**KIRKLEES METROPOLITAN COUNCIL
INVESTMENT & REGENERATION SERVICE**

**DELEGATED DECISION TO DETERMINE APPLICATIONS FOR
CONSENT, AGREEMENT OR APPROVAL REQUIRED BY CONDITION**

Reference No:	2024/44/92576/W
Site Address:	site of, Former Spotted Cow Pub, New Hey Road, Oakes, Huddersfield, HD3 4BU
Description:	Discharge of details reserved by conditions 3 (CMP), 21 (retaining walls), 23 (surface water) and 28 (non-native species) of previous permission 2021/94029 for demolition of existing structures and erection of foodstore (class E) with associated access, parking, servicing areas and landscaping
Recommending Officer:	Victor Grayson

DECISION – Discharge of Condition – Split Decision

SECTION 5

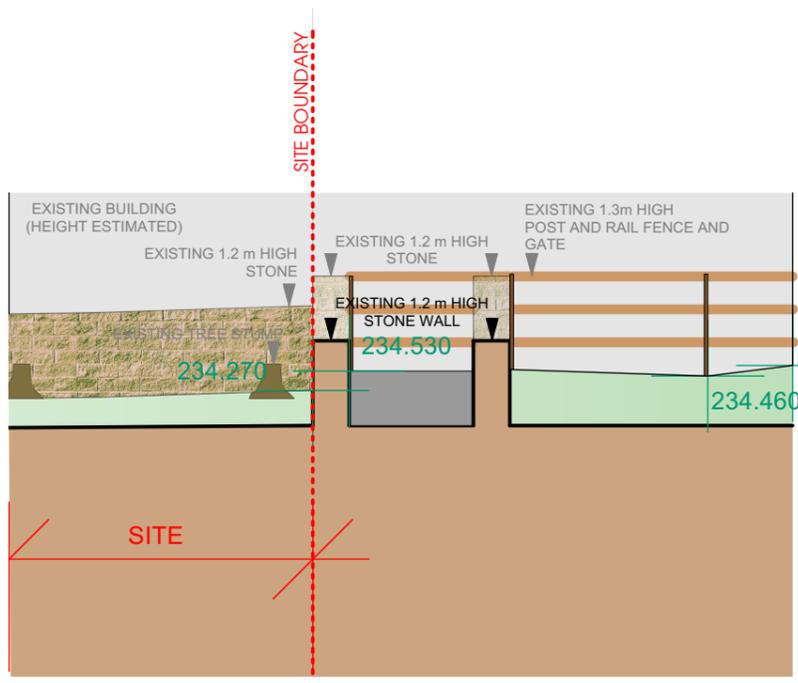
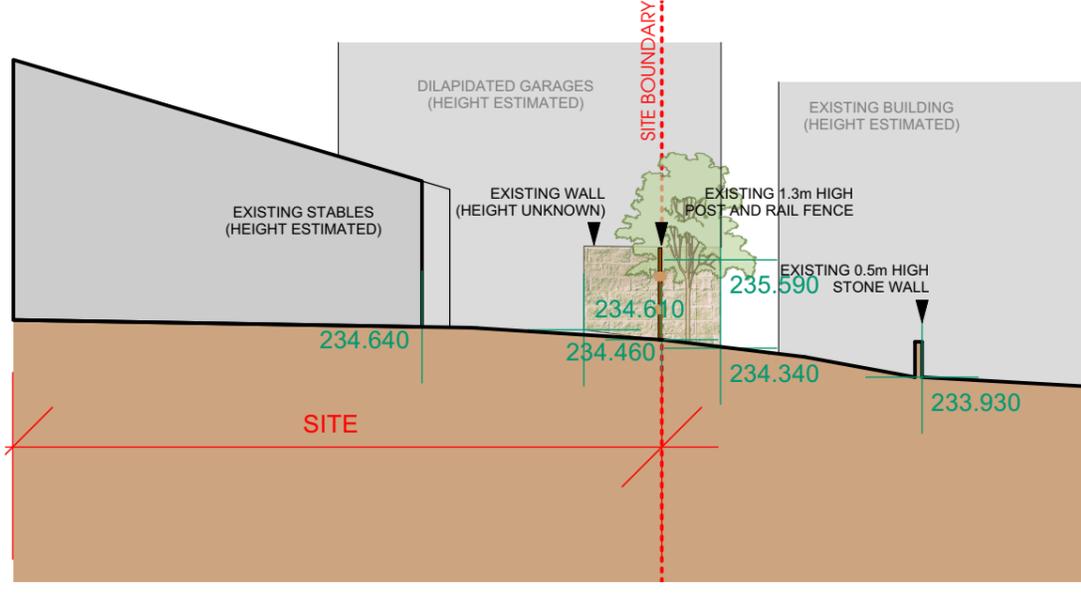
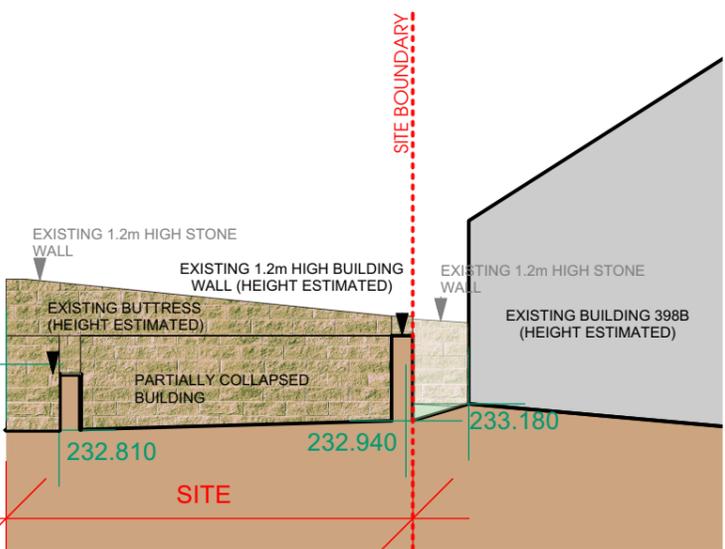
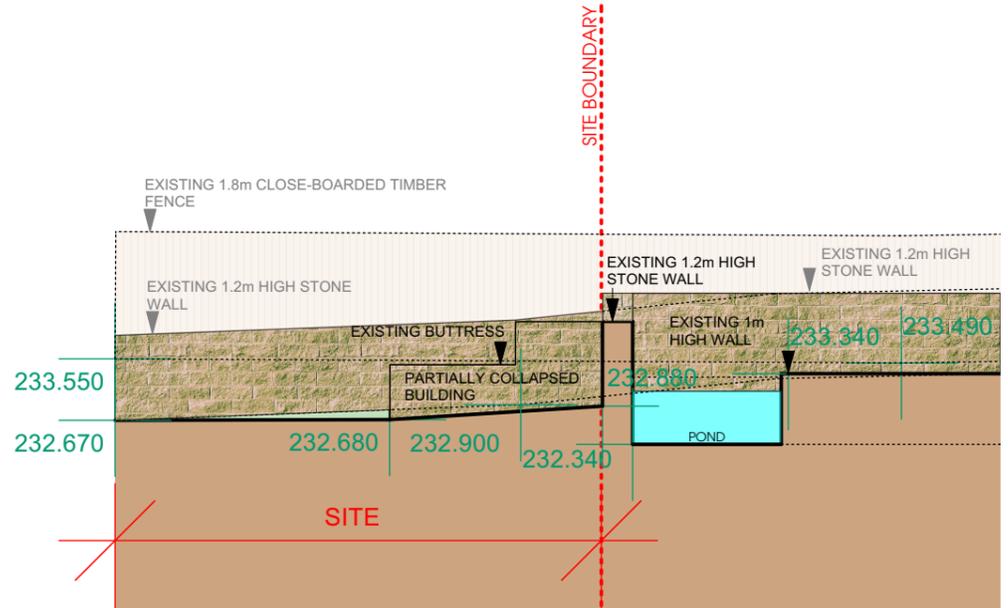
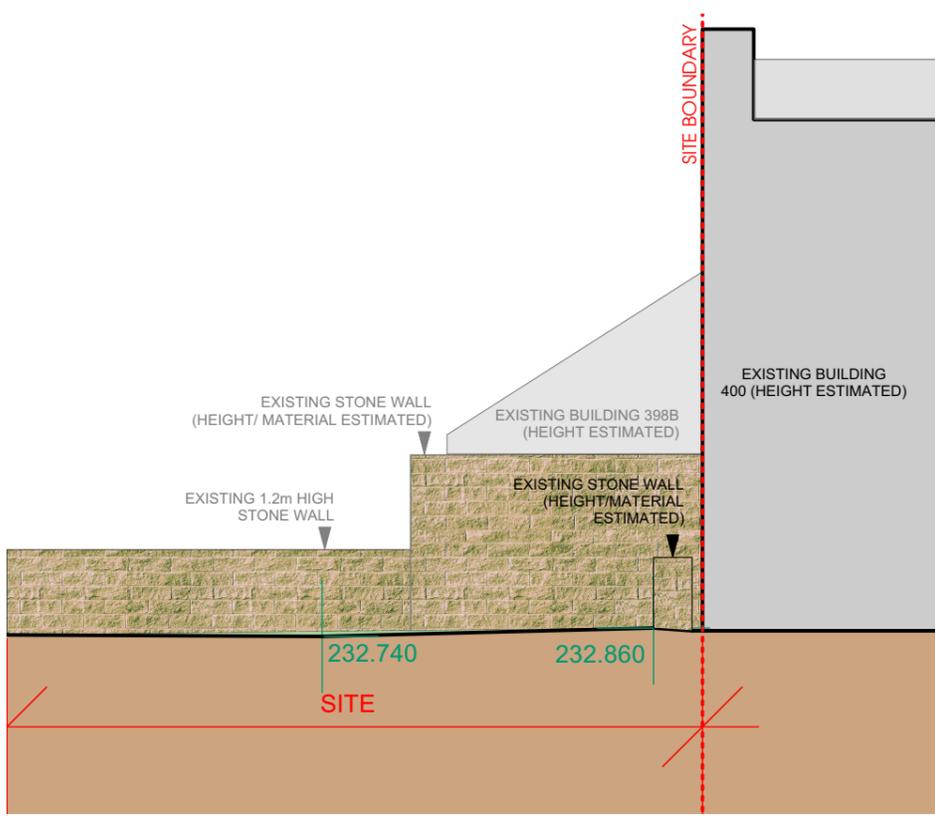
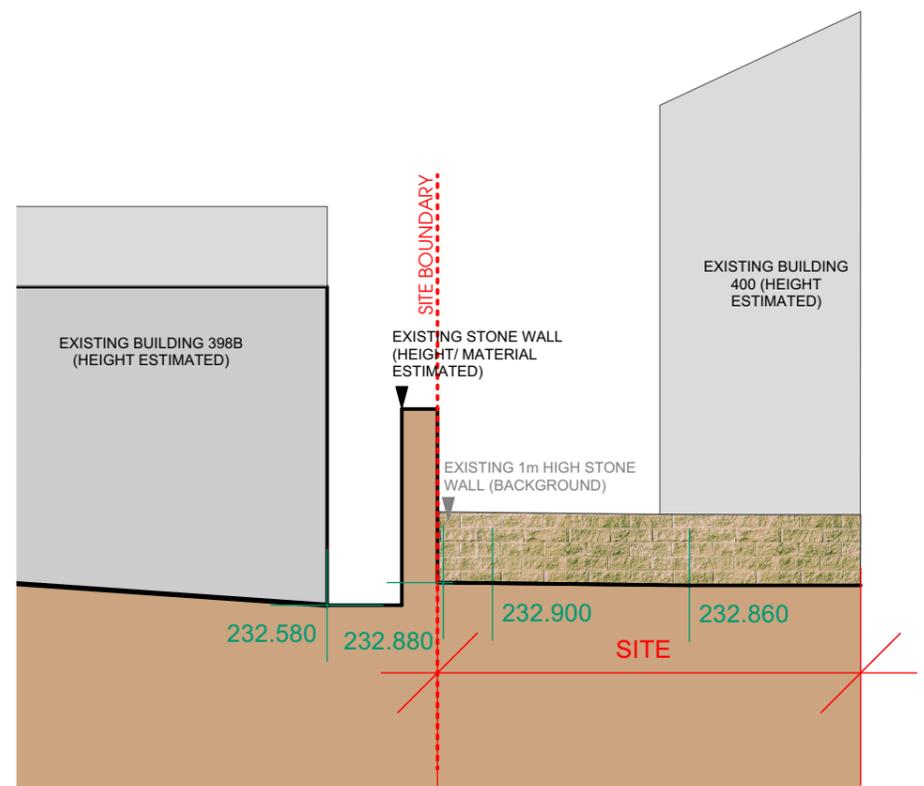
KC Highways Structures: Condition 21 cannot be discharged, as the supporting information does not include the required dimensioned sectional details along the highway boundary (these are required to determine whether the design of proposed highway retaining structure will be liable to a formal technical approval via submission of an AIP).

In comments dated 12/09/2024, KC Highways Structures stated that condition 21 could not be discharged, as the supporting information did not include the required dimensioned sectional details along the highway boundary. These details are required by KC Highways Structures to determine whether the design of proposed highway retaining structure would be liable to a formal technical approval via submission of an Approval in Principle application.

In response, on 24/03/2025 the applicant asserted that the wall fronting “New Hey Road” is not a retaining wall, and that the existing stone wall would largely be retained, although there would be a small new section of wall where the existing site access is located – this would match the existing wall and would be non-retaining. On 01/04/2025 the applicant submitted a section of this wall, however on 12/05/2025 the case officer queried why levels on that drawing

appeared to differ to what had been shown at application stage. On 26/06/2025, acknowledging an error in the previous drawing, the applicant submitted a drawing titled “Boundary Wall – Section B-B Conditions” (drawing P1301 rev A).

KC Highways Structures have been consulted on this further drawing and the applicant’s accompanying commentary, and their comments are expected in due course. In the meantime, it is not recommended that an approval be issued pursuant to condition 21.
